Re: Flying Horse North Filing No. 4 Preliminary Acceptance Punchlist Items

A Redlined As-built set of Construction Drawings sealed and stamped by a licensed Colorado Professional Engineer has been supplied to the County for review as a part of this filing's request for preliminary acceptance. The content below are the supplied construction punchlist items as developed by DPW and Stormwater via a walk-through completed on June 9, 2026. The Developer has since remediated and proposed acceptable alternatives approved by the Engineer of Record to satisfy the County's listed requirements. Responses are provided below after each listed item.

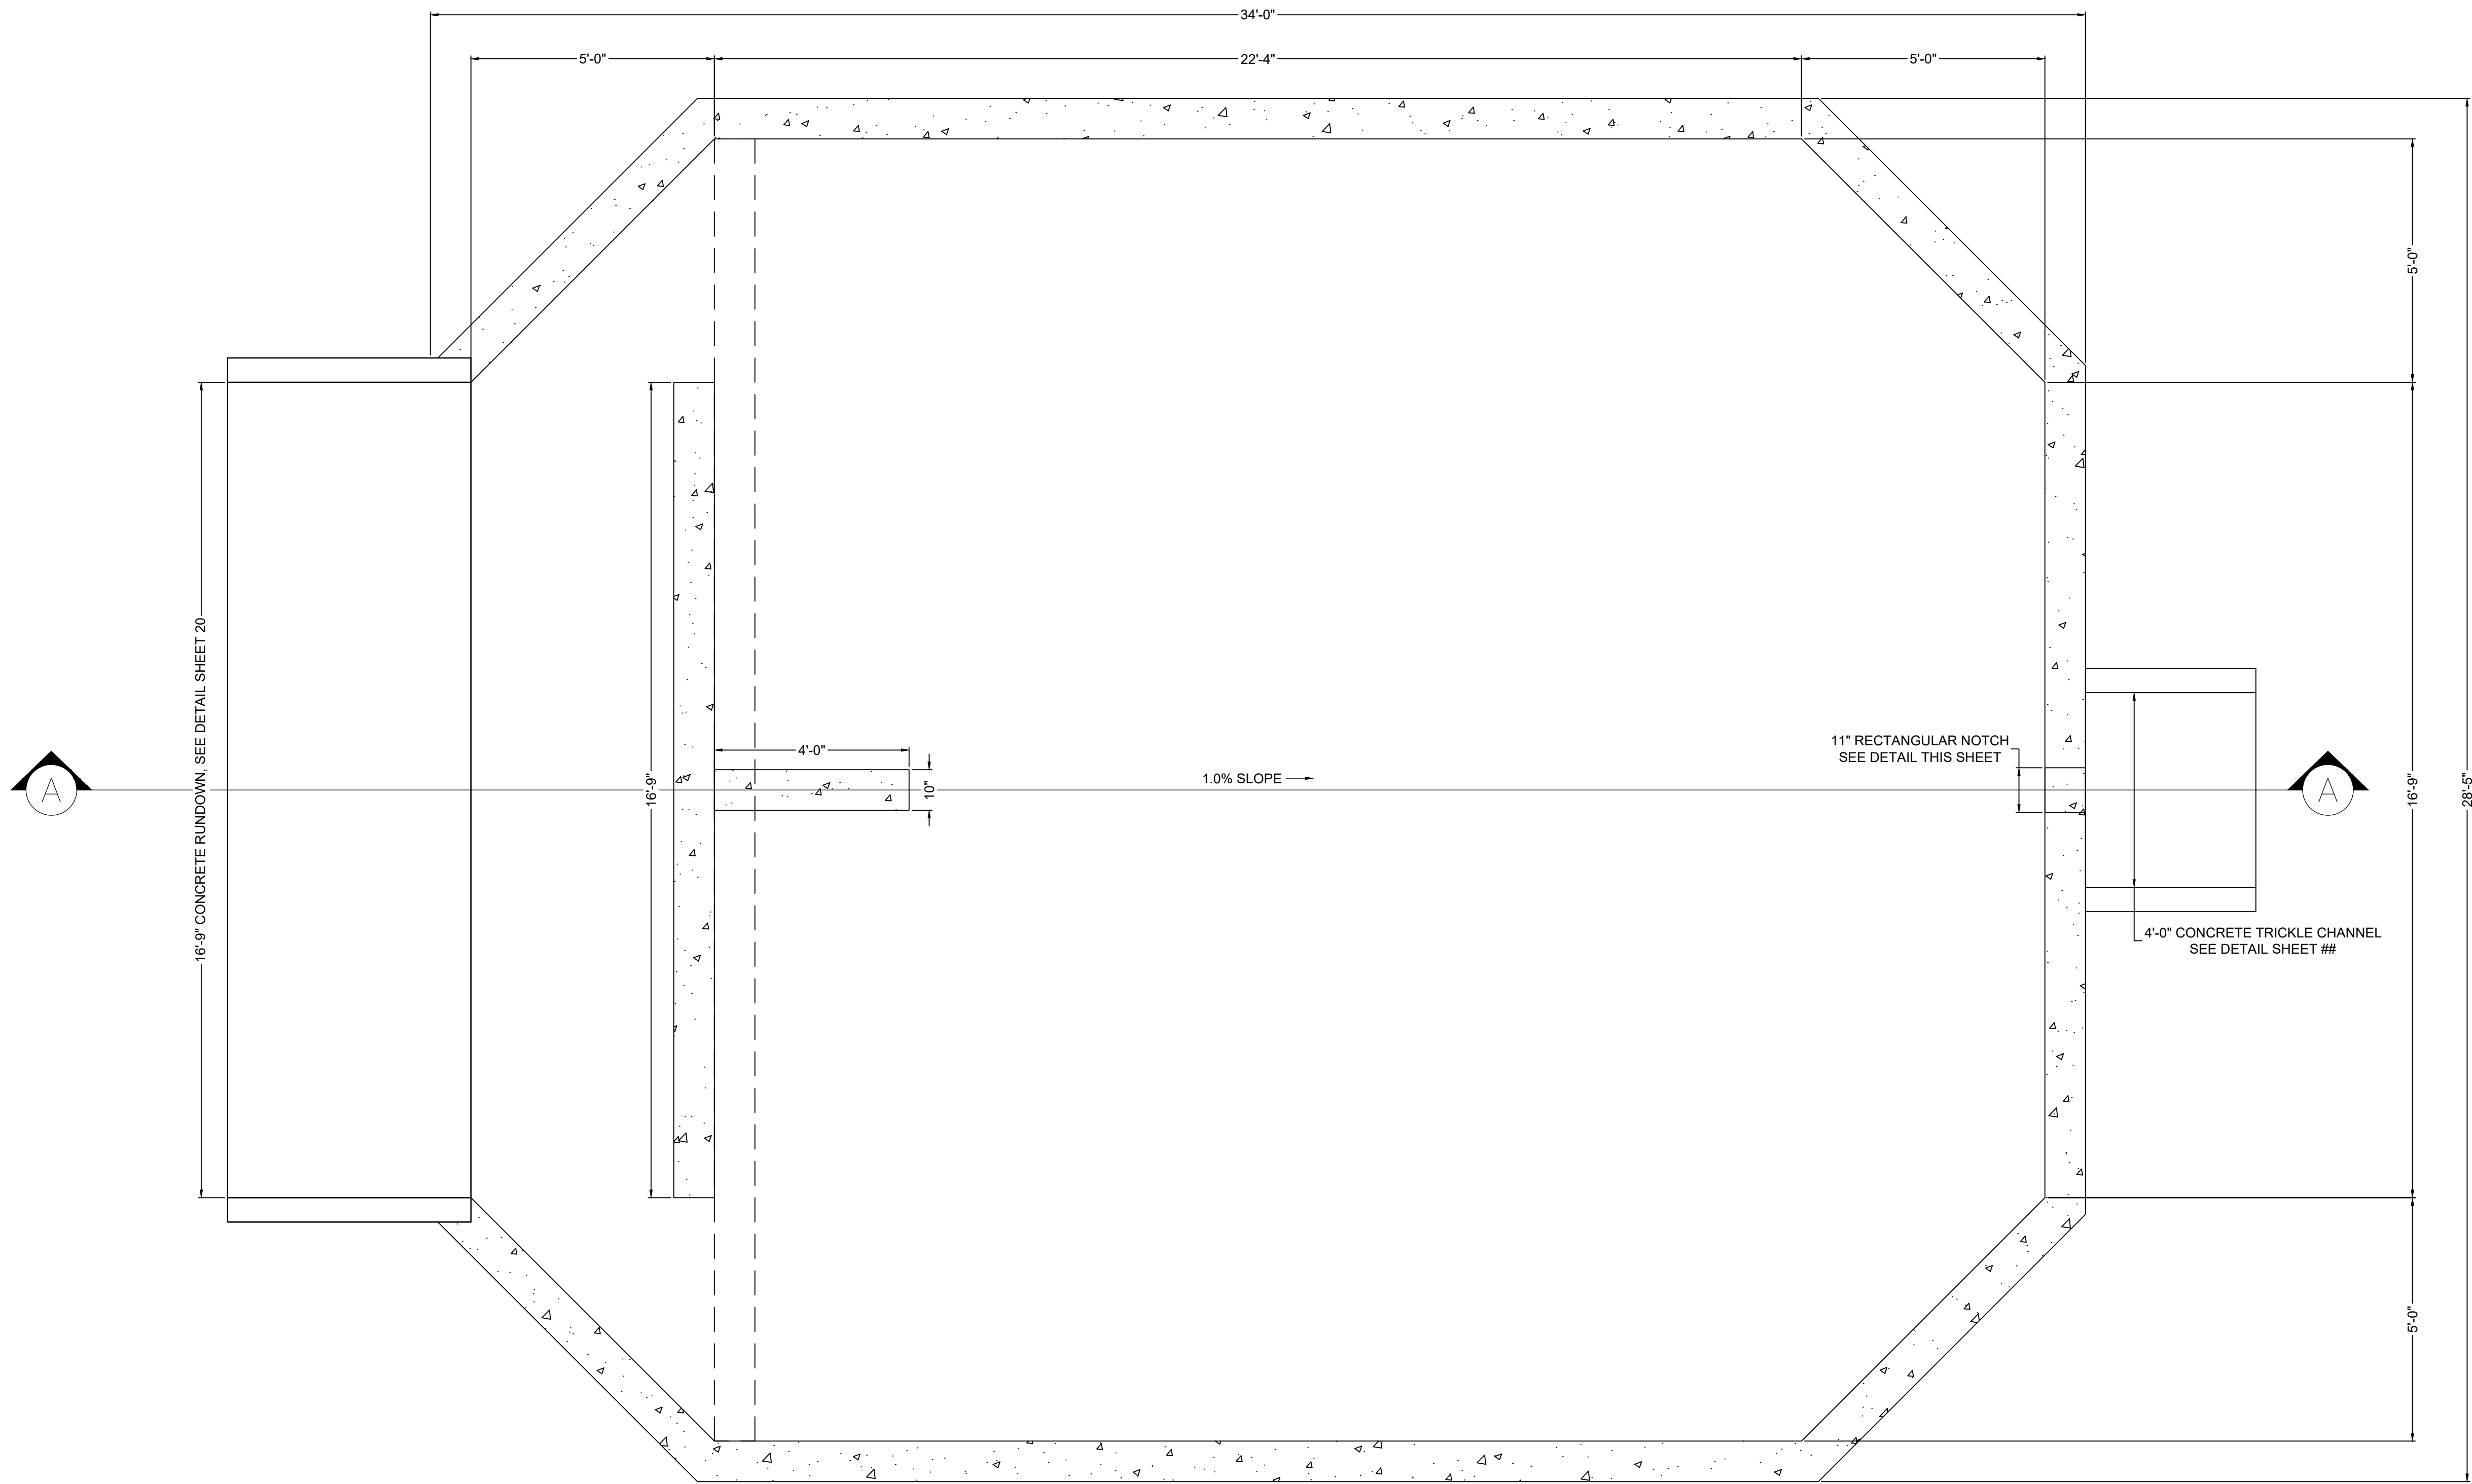
- “Ladder” steps are missing from micro pool. Install per approved plans. ***Ladder steps installed to match Construction Drawings.***
- Outfall Riprap

- Outfall riprap is not installed per the approved plans. Plans show buried riprap and in the field it is installed as exposed riprap. Install per approved plans or consult the Engineer of Record. See Note 1. ***Outfall/spillway rip-rap is exposed rip-rap and is now reflected on the as-builts, as approved by the Engineer of Record.***

- Undermining observed at downstream end of outlet pipe. Repair such that this doesn’t get worse or continue to happen. ***A more defined conveyance swale shape is constructed to contain flows and minimize undermining. Exposed rip-rap allowed by Engineer of Record, as-built redlines address the change.***

- Maintenance access road installed with crushed concrete, which per direction from CDPHE is not an acceptable means of Final Stabilization, nor was that material on the approved plans, so please remove and install access road material per plans. ***As-built plans and redlines now call out crushed concrete as approved by the Engineer of Record. This was discussed with Stormwater staff in July 2026 and is to be allowable for this filing.***

29

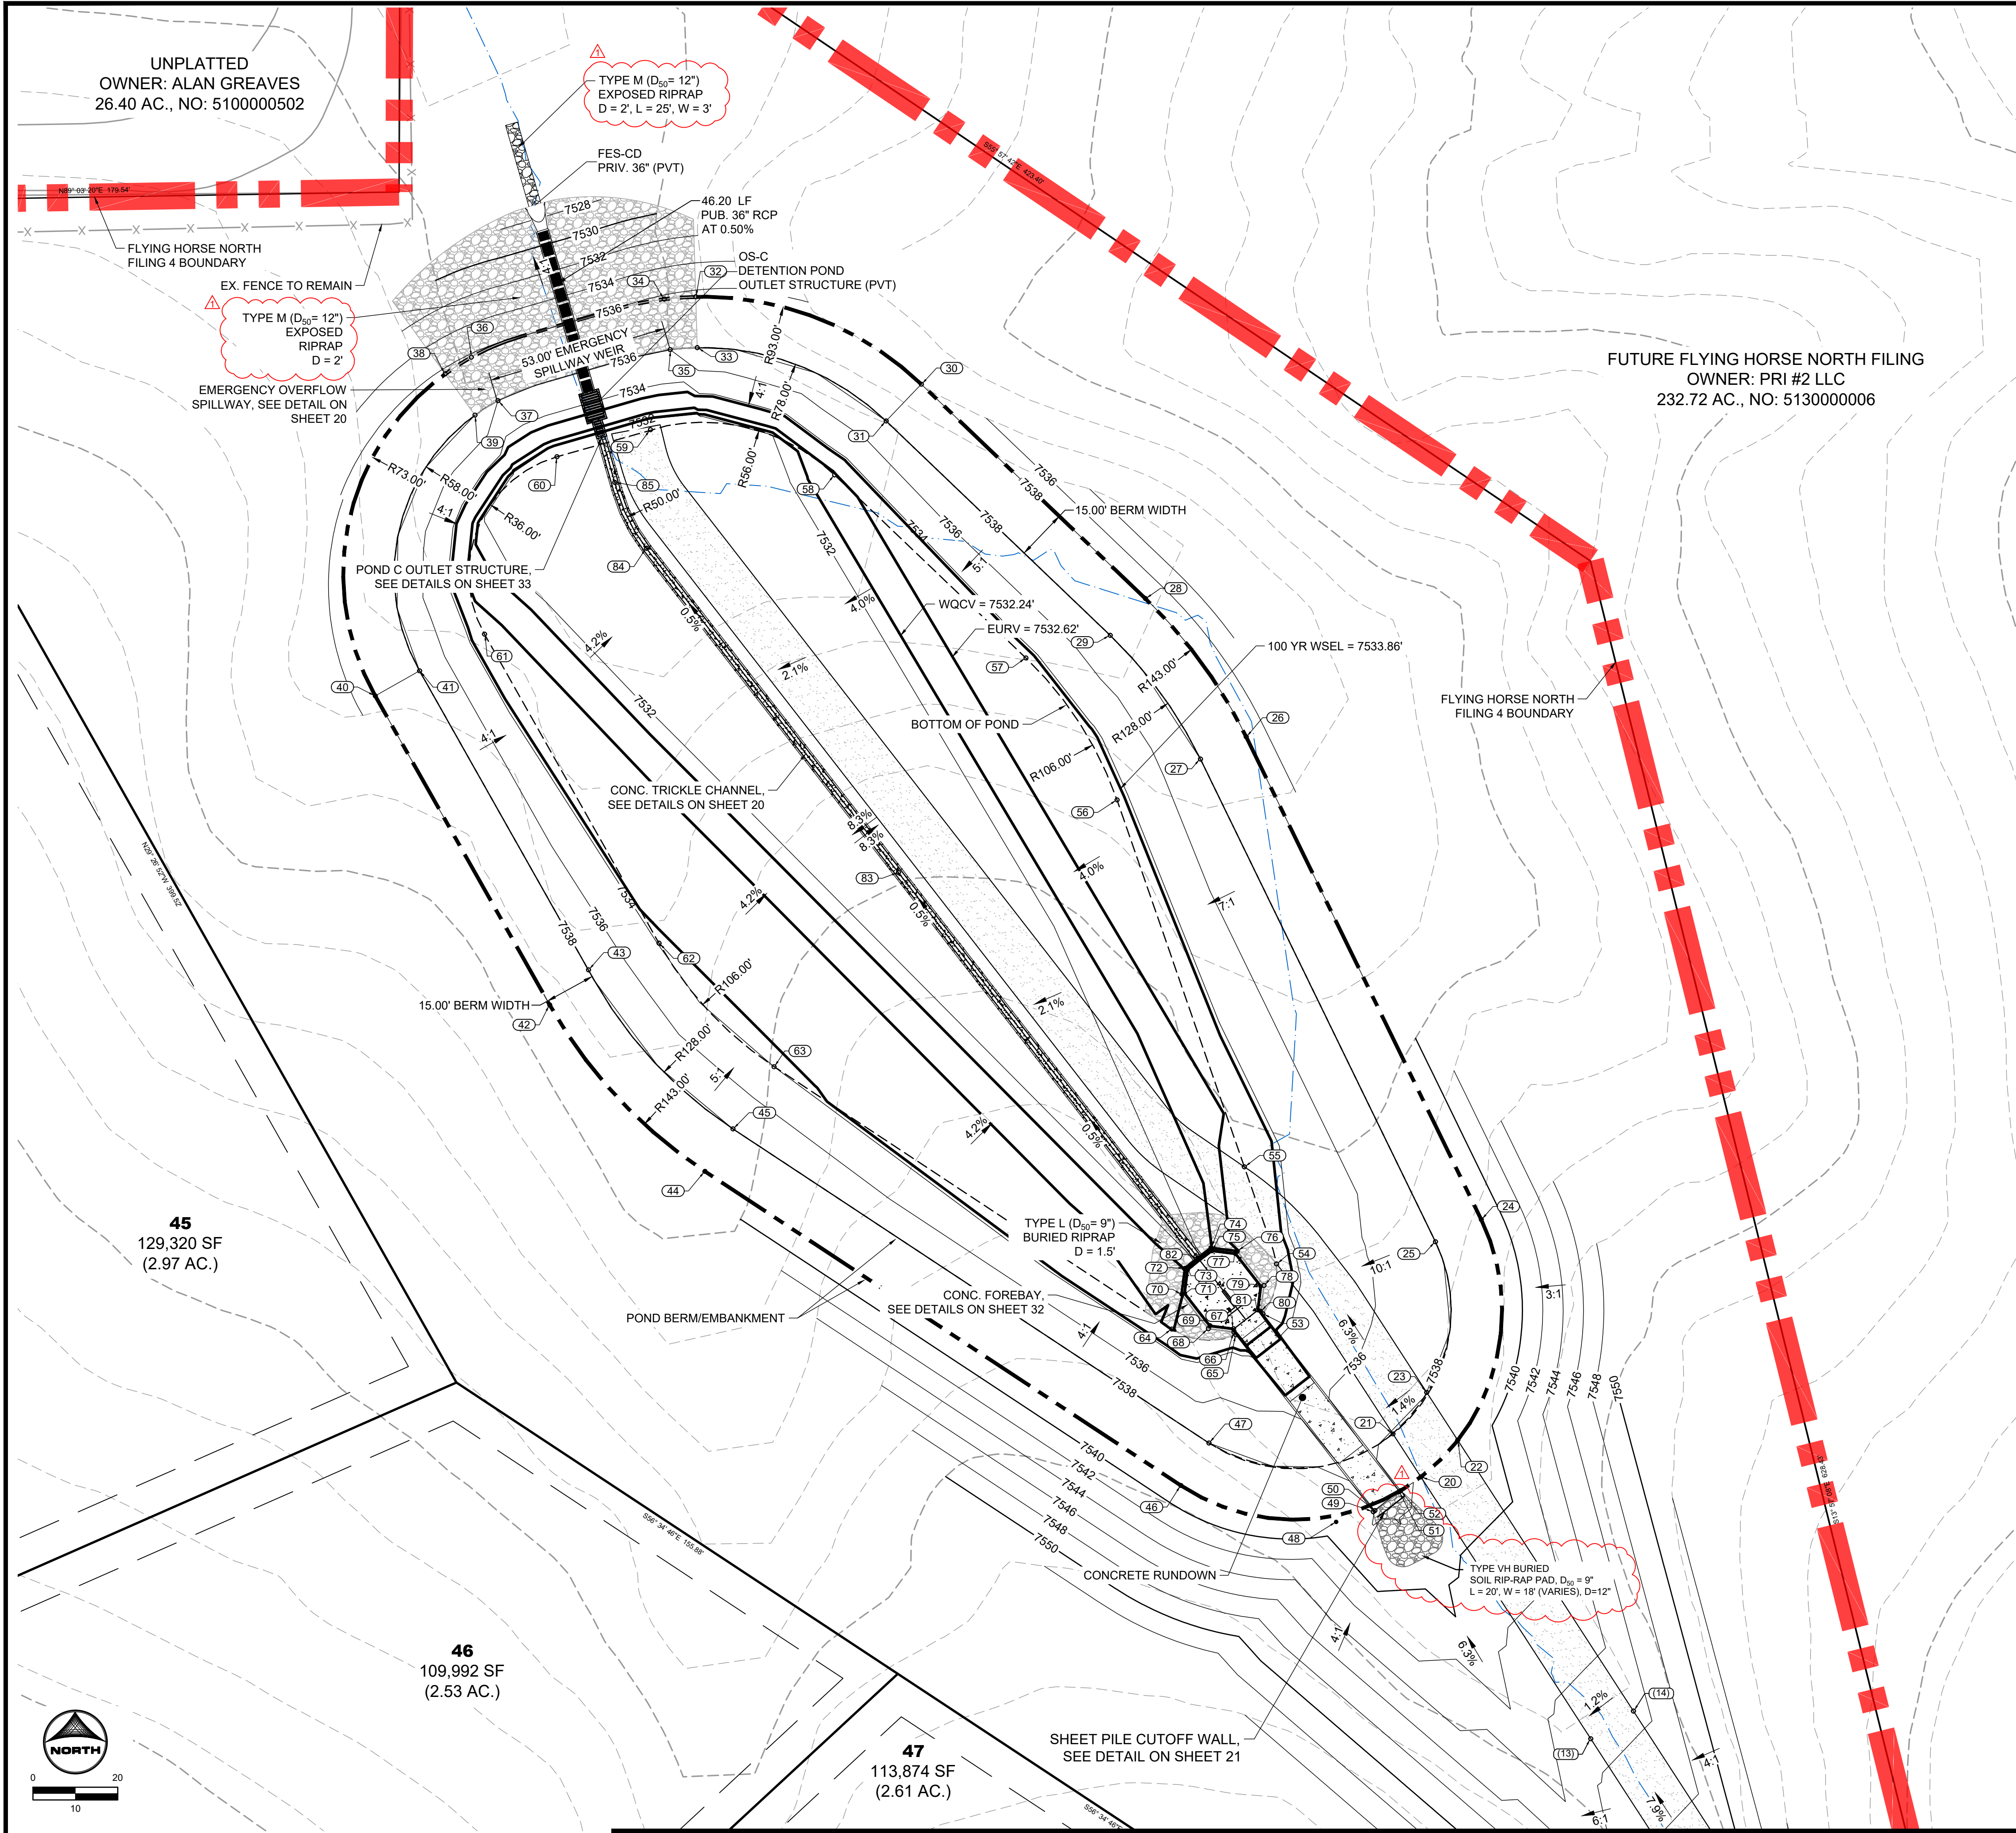
- Inflow Riprap Upstream of Forebay
 - Riprap at the forebay inflow is not shown on the approved plans. Consult the Engineer of Record and provide supporting documentation as needed. See Note 1. ***As-built redlines have added this condition.***
- Forebay
 - Remove sediment from forebay. ***Sediment removed.***
- Trickle Channel
 - Remove sediment from trickle channel. ***Sediment removed.***
- Outlet Structure
 - Remove sediment from the outlet structure. ***Sediment removed.***
 - “Ladder” steps missing from micro pool and outlet structure. ***Ladder steps installed to match Construction Drawings.***

- Outfall Riprap
 - Riprap at the pond outfall is not installed per the approved plans. Plans show buried riprap and in the field it is installed as exposed riprap. Install per approved plans or consult the Engineer of Record. See Note 1. **Outfall/spillway rip-rap is exposed rip-rap and is now reflected on the as-builts, as approved by the Engineer of Record.**

- Also, the riprap apron is not shaped to convey flows. It is piled up such that there is no positive drainage and flows will just bypass the riprap and cause erosion. So please reconfigure riprap to properly convey flows. **A more defined conveyance V-shape swale has been constructed.**

- Maintenance access road installed with crushed concrete, which per direction from CDPHE is not an acceptable means of Final Stabilization, nor was that material on the approved plans, so please remove and install access road material per plans. **As-built plans and redlines now call out crushed concrete as approved by the Engineer of Record. This was discussed with Stormwater staff in July 2026 and is to be allowable for this filing.**
